Application no: **3/2022/1171**

Address: **6 The Grove Whalley BB7 9RN**

Proposal: **Proposed two storey side extension.**

The Local Highway Authority have viewed the plans and highway related documents and have the following comments to make:

6439 - P01

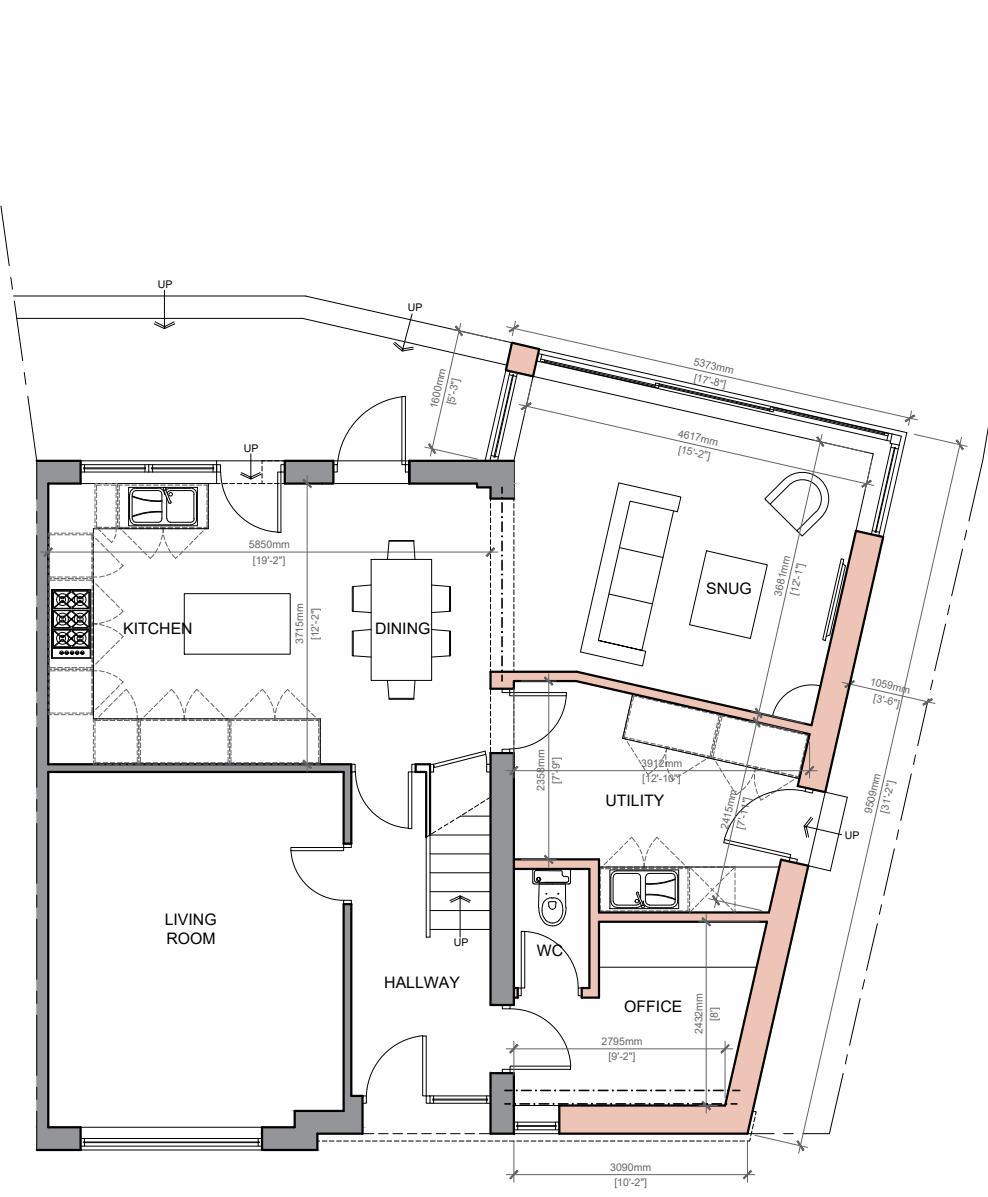
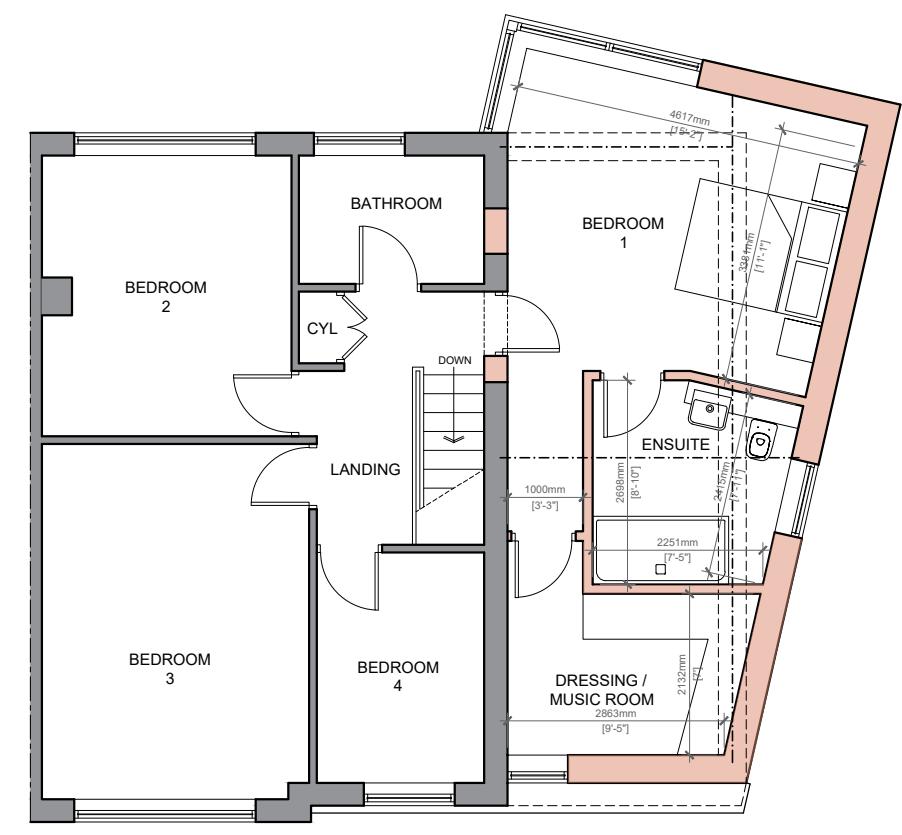
The LHA have reviewed the supporting documents and are aware that the existing 3 bed dwelling will become a 4-bed following the proposal. For the site to comply with the LHAs parking guidance as defined in the Joint Lancashire Structure Plan, the LHA require 3 car parking spaces to be provided on site. However, the site can only provide 2 car parking spaces.

Despite this, the LHA will accept the shortfall in parking with the dwelling being located in a sustainable location within walking distance of the centre of Whalley where key local amenities and public transport facilities such as Whalley Train Station and the local bus station are found.

However, the LHA will condition that the dwelling provides some form of cycle storage facility to make up for the shortfall in car parking.

1. Following completion of the two storey extension, a cycle storage plan for the residential unit should be submitted to the Local Planning Authority, in consultation with the Local Highway Authority. These cycle facilities shall thereafter be kept free of obstruction and available for the parking of bicycles only at all times.
